## WEST SUSSEX COUNTY COUNCIL CONSULTATION

| <b>LOCATION:</b>                | 25 River Road<br>Littlehampton<br>BN17 5BZ                                                                                                                                                                                                   |
| <b>SUBJECT:</b>                 | LU/126/19/PL<br><br>Demolition of the existing garage building (B2 industrial use) and redevelopment of the site providing 9no C3 residential units - This application affects the character and appearance of River Road Conservation Area. |

01 Ground Floor

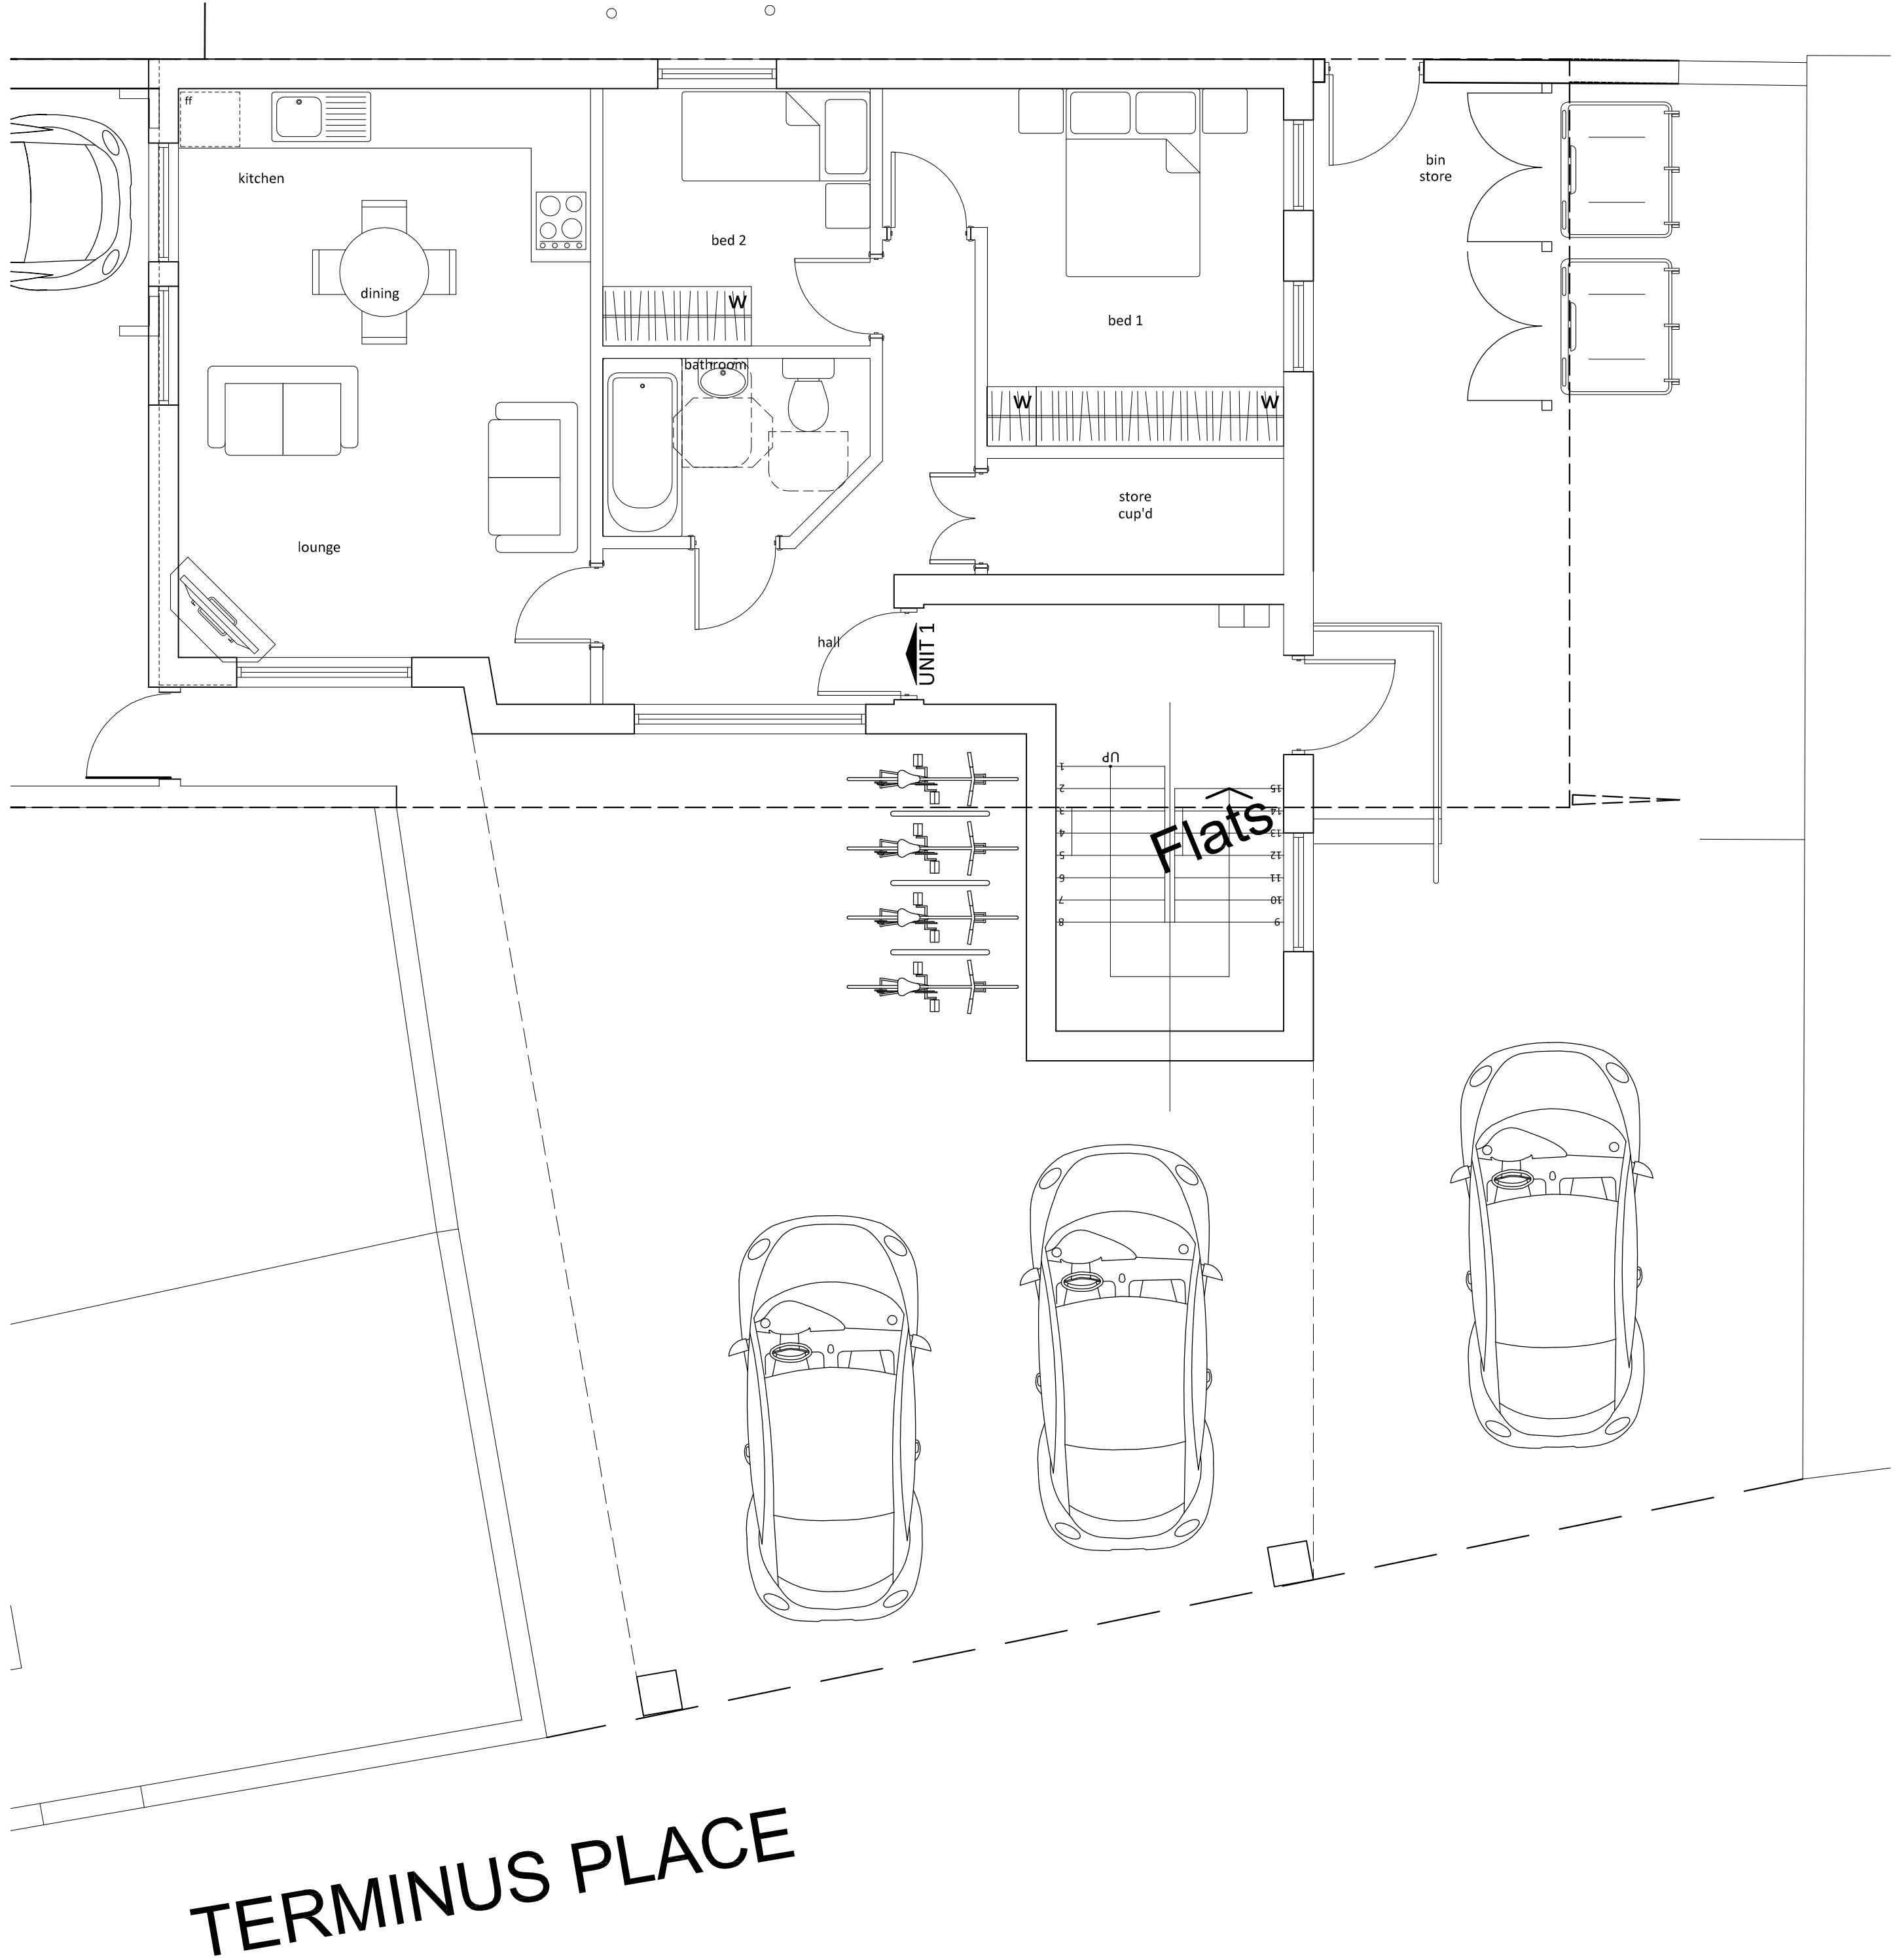
On inspection of the planning documents it has become apparent that the details regarding parking are not clear. The Planning Statement indicates that a space will be provided for each unit (9), yet the plans show only 6 spaces. Concerns are raised over parking capacity round the local roads. It is advised that the applicant carry out a parking capacity survey and provide clarification and more information on the parking strategy for the proposal. It would also be helpful to see vehicle tracking to demonstrate how each parking space can be accessed. Please re-consult once the requested information is provided.
